Deadline 8 submission

This submission sums up issues where we remain in disagreement with the Applicant.

From: 6.11.F3 Environmental Statement Figure 11.3 - Non-Designated Heritage Assets Assessed in the ES Chapter (Clean) (Final Issue D) [REP6-066] (Page 15/26)

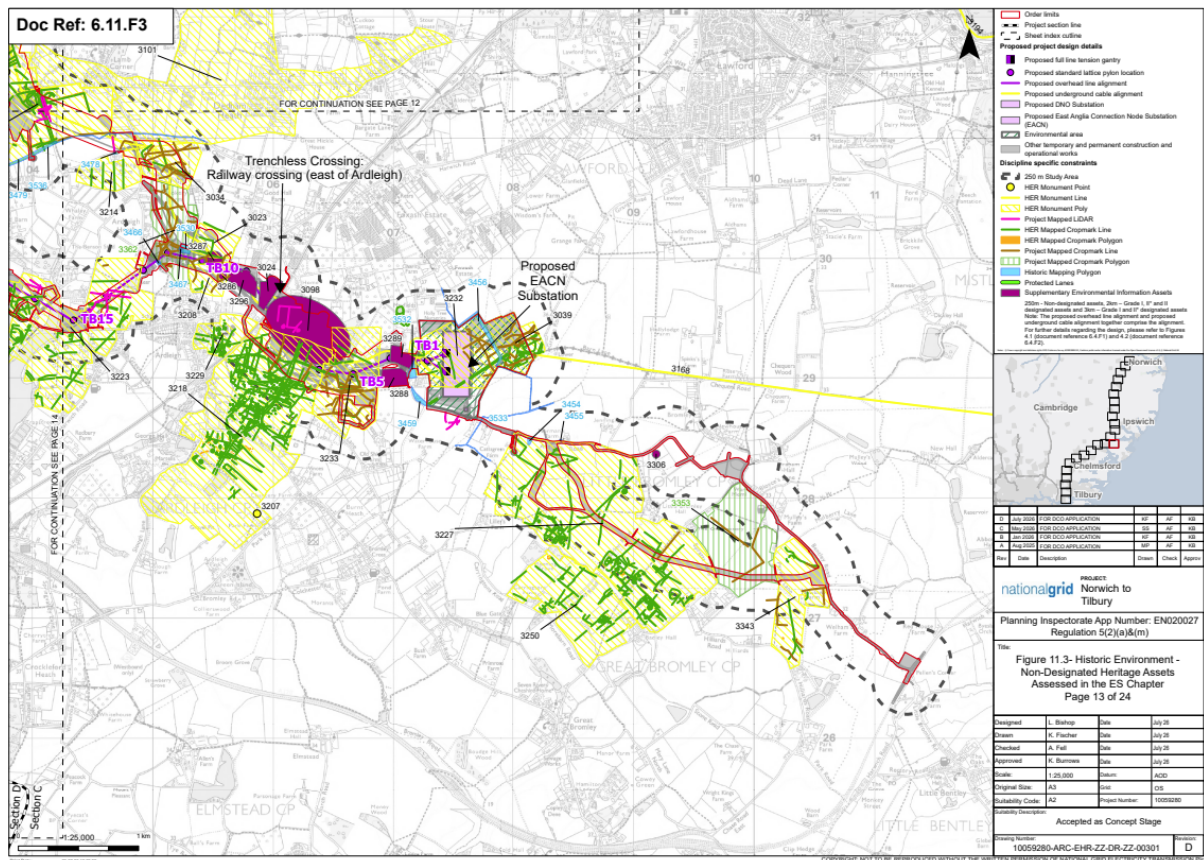
36. Similarly, in Ardleigh the Applicant has not taken on board information about the section of the Ardleigh Cropmark Complex intersected by the proposed project which is considered to have the archaeological potential to demonstrate equivalent significance to the scheduled monument. In submissions from Ardleigh Parish Council since 2022, the Applicant has been advised of the high archaeological potential of this area and therefore has not avoided the harm, not conducted surveys early enough in the project and not conducted the right type of survey or rerouted the infrastructure to avoid harm.

37. Past submissions have also highlighted that key information was missing from the Applicant's non-designated heritage asset maps. Information on the archaeology of the Ardleigh Cropmark Complex did not appear on the maps supplied by the Applicant until Examination had commenced. Other information is still missing from the maps.
